From: Jenny Evans. [REDACTED]
Sent: 25 October 2018 10:20
To: Planning
Subject: 53 Mill Road Avenue Extension

RE: 53 Mill Road Avenue Extension

A\130/18/NMA
A\159/18/HH
A\128/18/CLE
A\132/18/HH

REAR ELEVATION
East

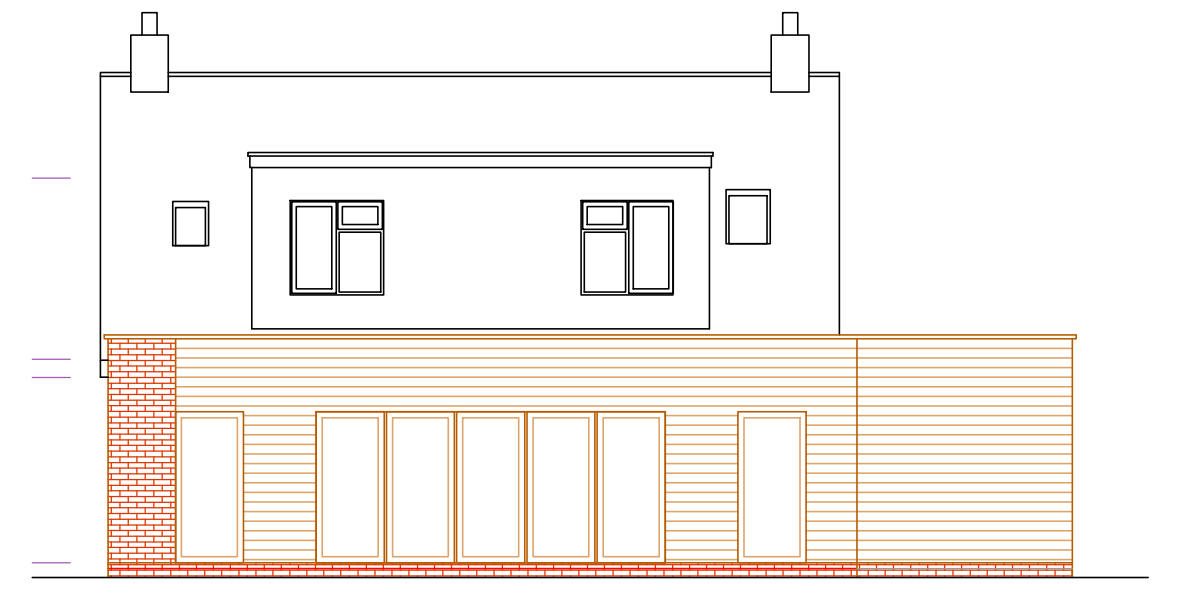
The issues around this extension has always been principally concerned with the finished aspect of the large, rear first floor elevation of the property.

The proposed cladding and vast areas of glass bear no relationship to adjacent properties.

On a personal note, the large rectangular extension dominates my back garden. Privacy issues become daunting, as there appear to be windows and glass doors overlooking numbers 57 and 59 of Mill Road Avenue.
